From: RFS Guardian <rfsguardian@id.ngcomms.net>
Sent: Thursday, 10 December 2020 3:27 PM
To: Coffs Council Email Account <coffs.council@chcc.nsw.gov.au>
Subject: NSW RFS Information Request - Lakes Estate Residential Subdivision (MP 05_0129 MOD 4) NSW AUS

Your reference: MP 05_0129
Our reference: DA-2006-01296-S4.55-1

Development Application

Lakes Estate Residential Subdivision (MP 05_0129 MOD 4) NSW AUS, 14//DP752856

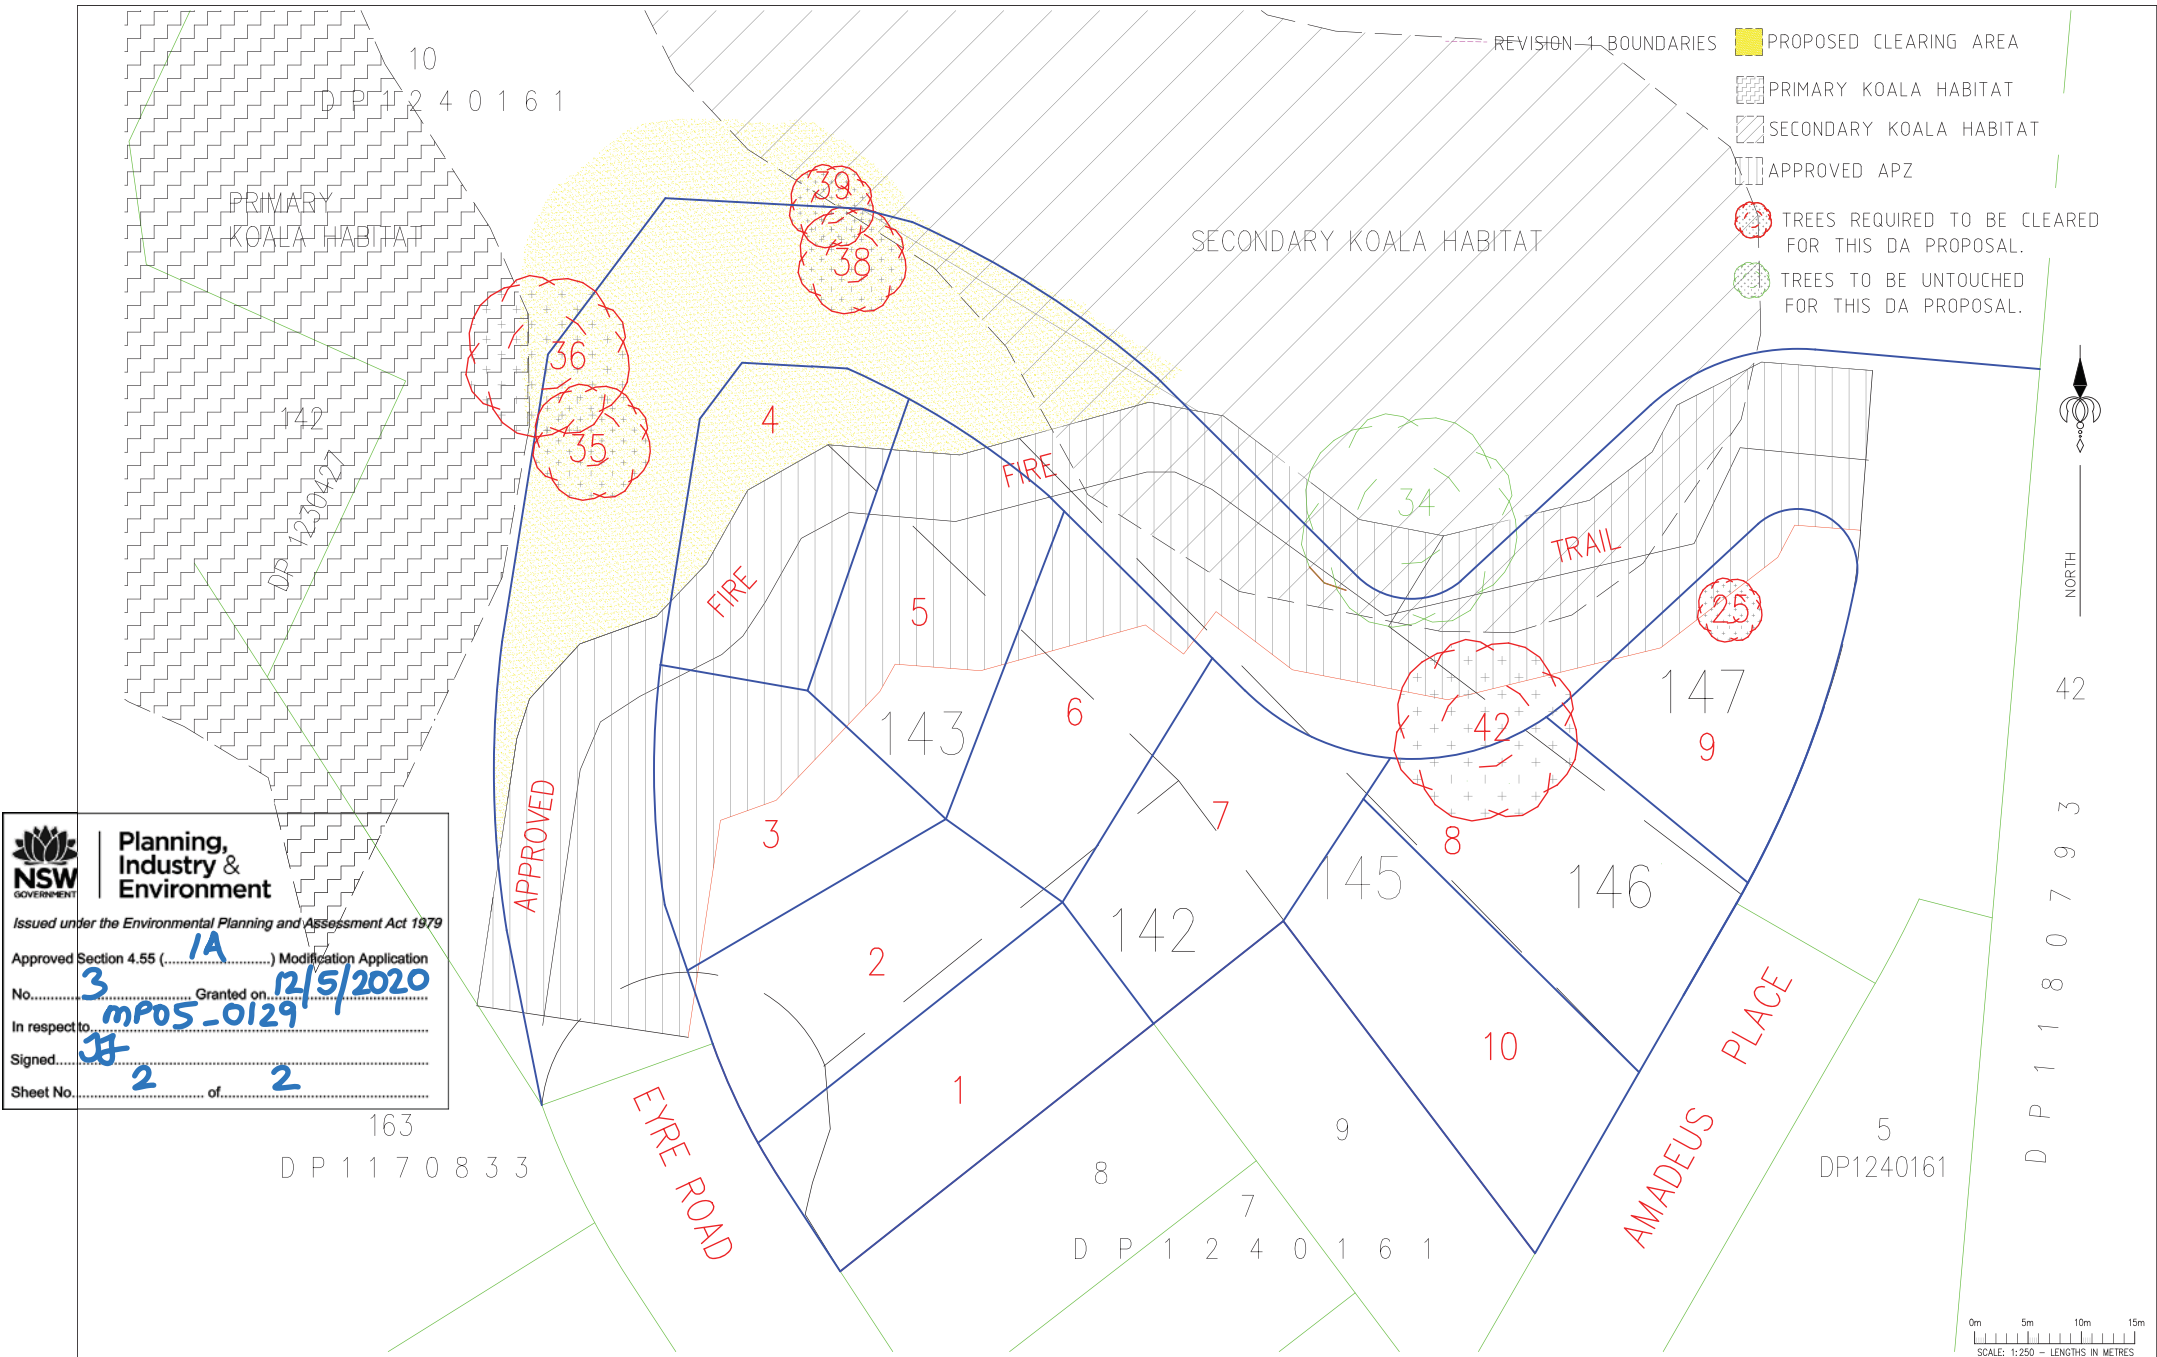
1. The proposed subdivision modification is not able to be supported by the NSW Rural Fire Service until evidence is submitted that indicates how proposed lot 6 is able to support a future dwelling being erected at BAL-29.

This request comes in response to information noted in Coffs Harbour City Council's (CHCC) letter to NSW Department of Planning, Industry and Environment, dated 17/11/2020, where it is stated that CHCC is not able to support part of a required APZ being located within land proposed to be dedicated to Council. The location of the APZ is identified to be repositioned to be wholly contained within the private lots so that Council is not required to maintain APZ.

It appears that a very small triangular area, within proposed lot 6, will likely be available for erection of a dwelling after accounting for the required (repositioned) APZ and usual front building line setback. Proposed lots 5 and 6 will also have some impact, but to a far lesser degree.

2. The cul-de-sac will need to be at least 10 metre in radius, be provided with roll top kerbing and have no parking permitted within the cul-de-sac head. This is noted to be smaller than the PBP 2019 outcome of 12 metre radius however it is noted that such an outcome is tenible in association with the turning head, located to the SSW and directly adjacent to the cul-de-sac, being compliant with the vehicle turning head requirements of Appendix 3 of PBP 2019. This outcome is able to be conditioned in future advice from the NSW Rural Fire Service.
